REQUEST

Current Zoning: UR-C(CD) (urban residential-commercial, conditional) and ML-2 (manufacturing and logistics-2)
Proposed Zoning: UR-C(CD) SPA (urban residential-commercial, conditional, site plan amendment)

Approximately 1.32 acres located along the west side of Seigle Avenue and east side of Van Every Street, south of Belmont Avenue.

STAFF RECOMMENDATION

Skyline Townes
Rezoning Site Plan
 955 Seigle Avenue Charlotte, North Carolina

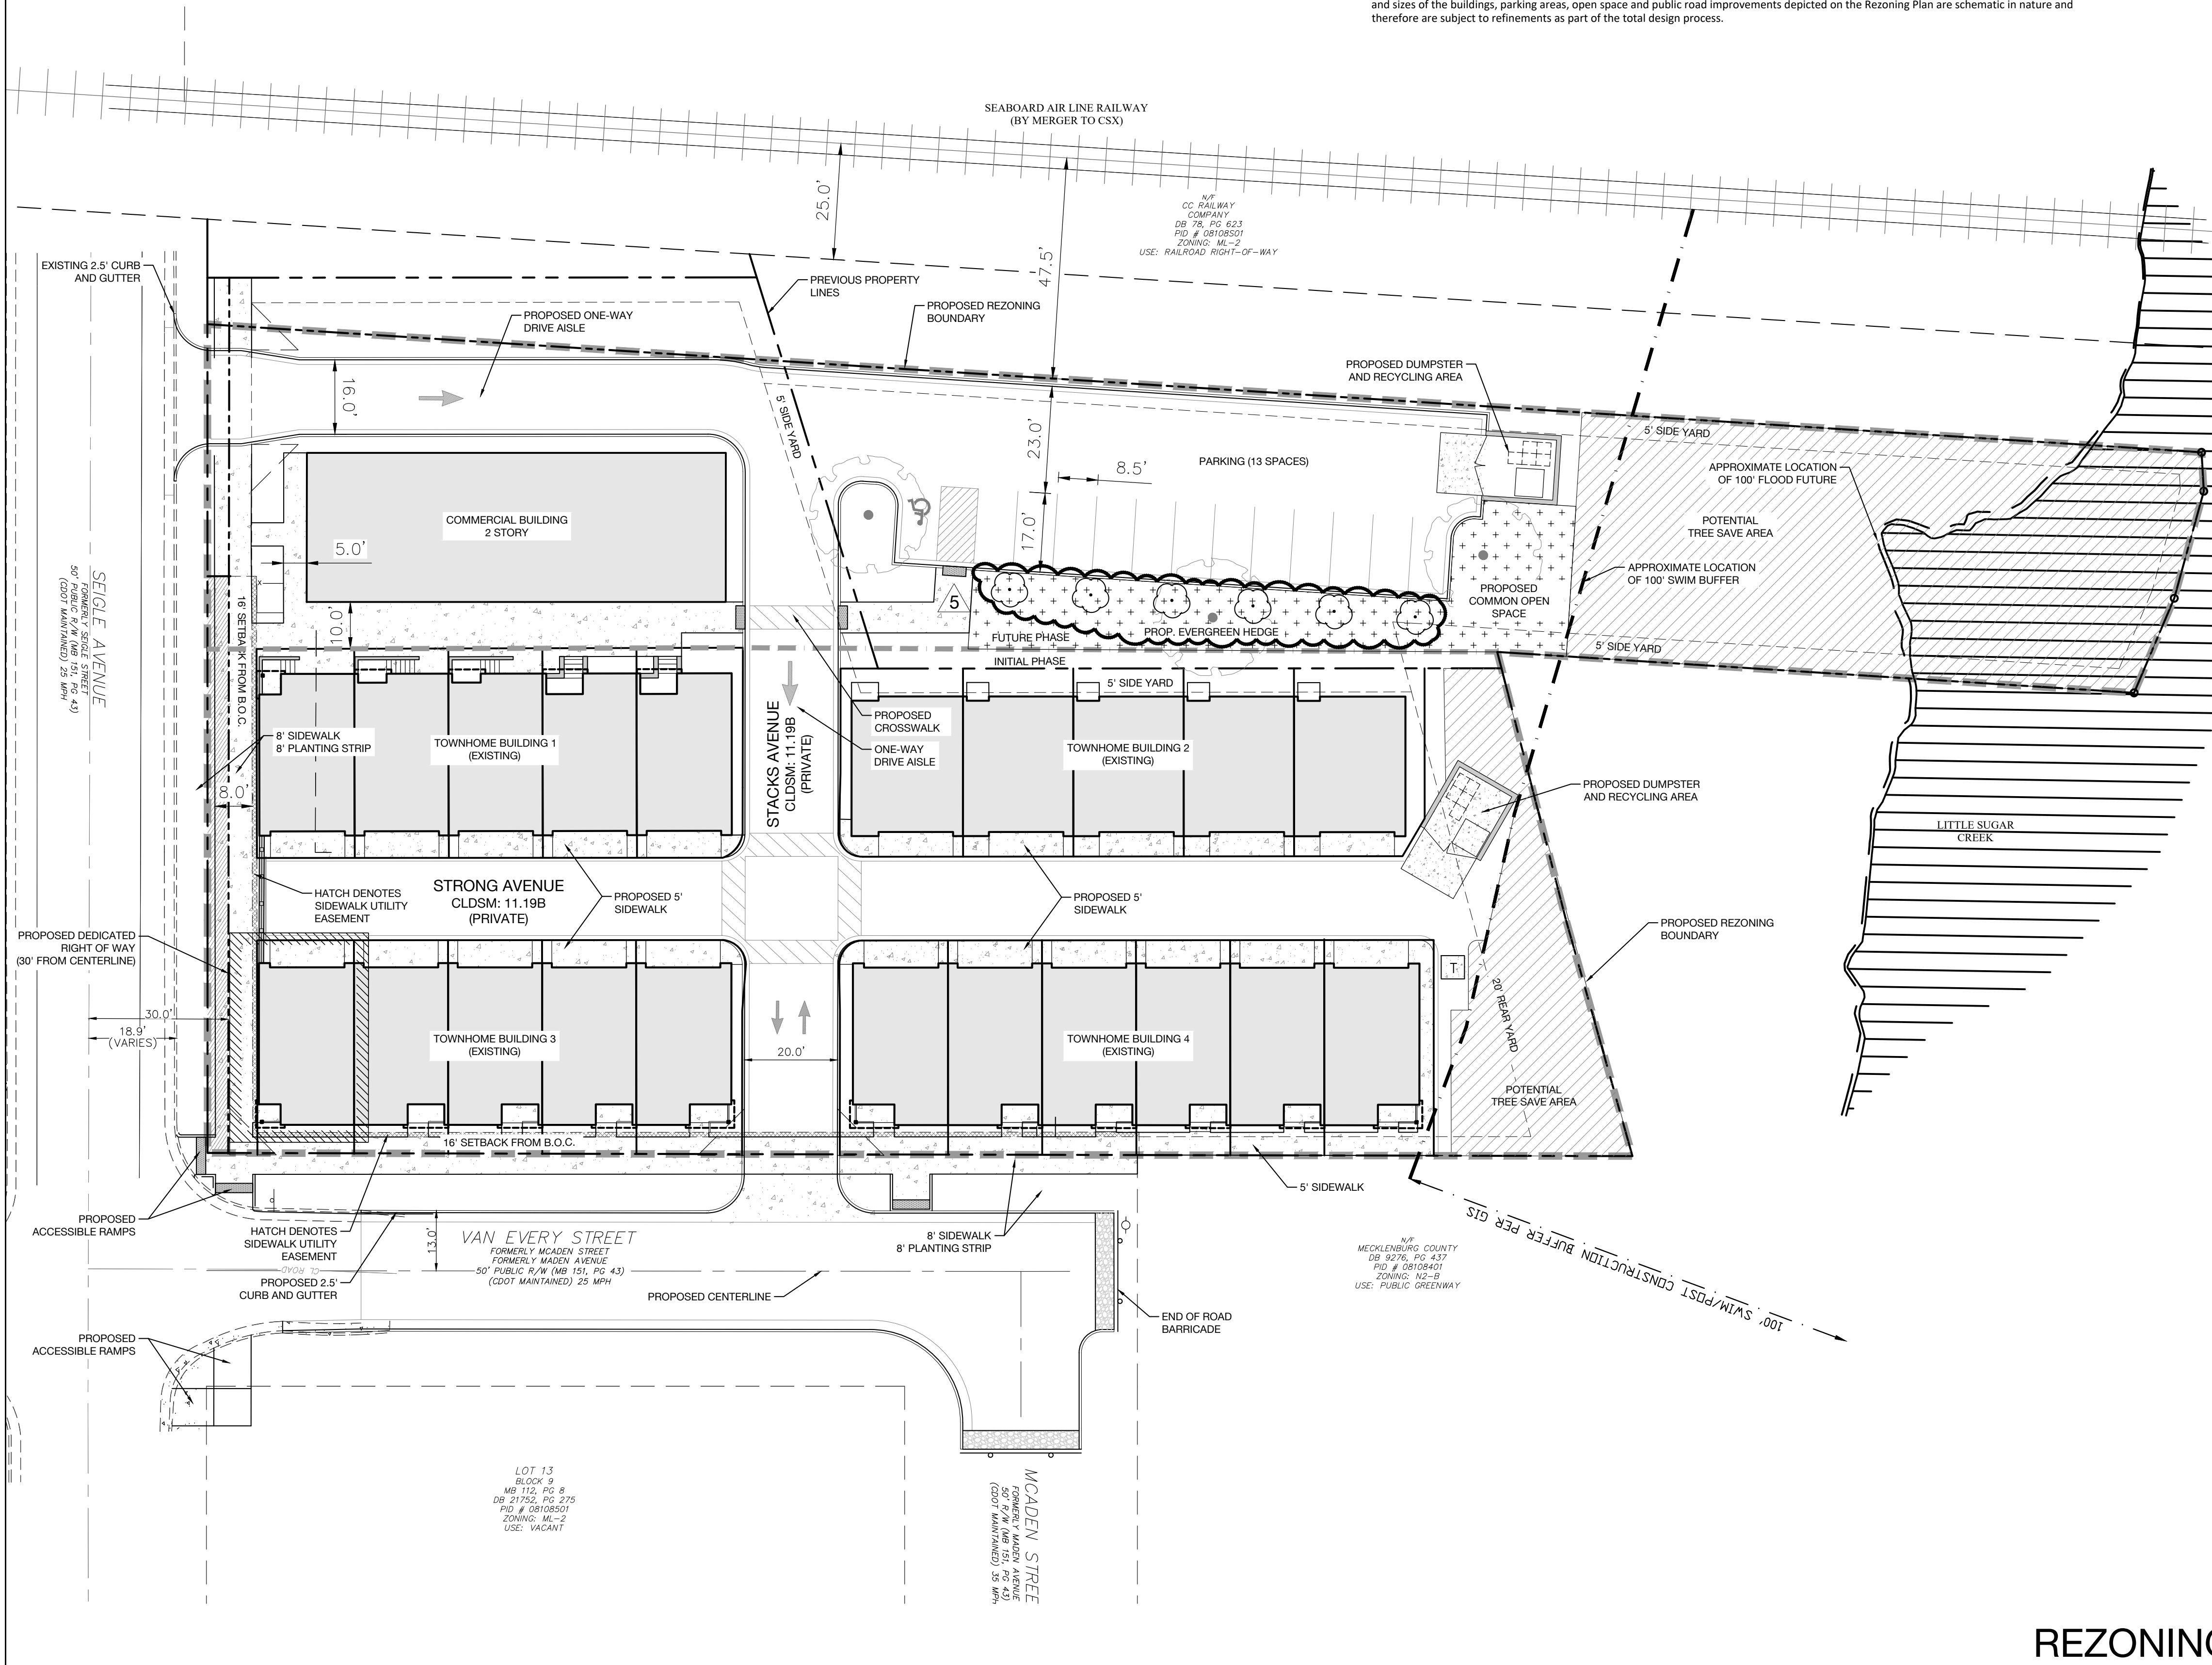
- **Mecklenburg County Parks and Recreation Department:** No outstanding issues.
- **Stormwater Services Land Development Engineering:** Buffer is to be measured from field-located top of bank of stream, not as shown on GIS. Please verify. See advisory comments at www.rezoning.org

- ~~1. There is a discrepancy on the site plan with regard to acreage. Site Development Data specifies 1.32 acres while General Provisions Note 1 specifies 1.27 acres.~~
2. Parking lots for more than 10 automotive vehicles and parking decks, excluding new and used automotive sales lots and parking areas for detached, duplex, triplex or quadraplex dwellings on a single lot; (Ref. Sec. 12.303). This will be applicable to parking area abutting railroad right-of-way. In addition, petitioner should consider screening commercial parking area from residential units. **Not addressed.**
- ~~3. Please confirm vicinity map matches rezoning boundary modification.~~
- ~~4. Please confirm Architectural and Design Standards Note 3.a as Permitted Uses Note 1.a states the existing building will be demolished.~~

5. Show tree save calculations. Any tree save that is being replanted must be done at 150%.
Update: Missing calculations and numbers do not appear to be accurate. **Not addressed.**
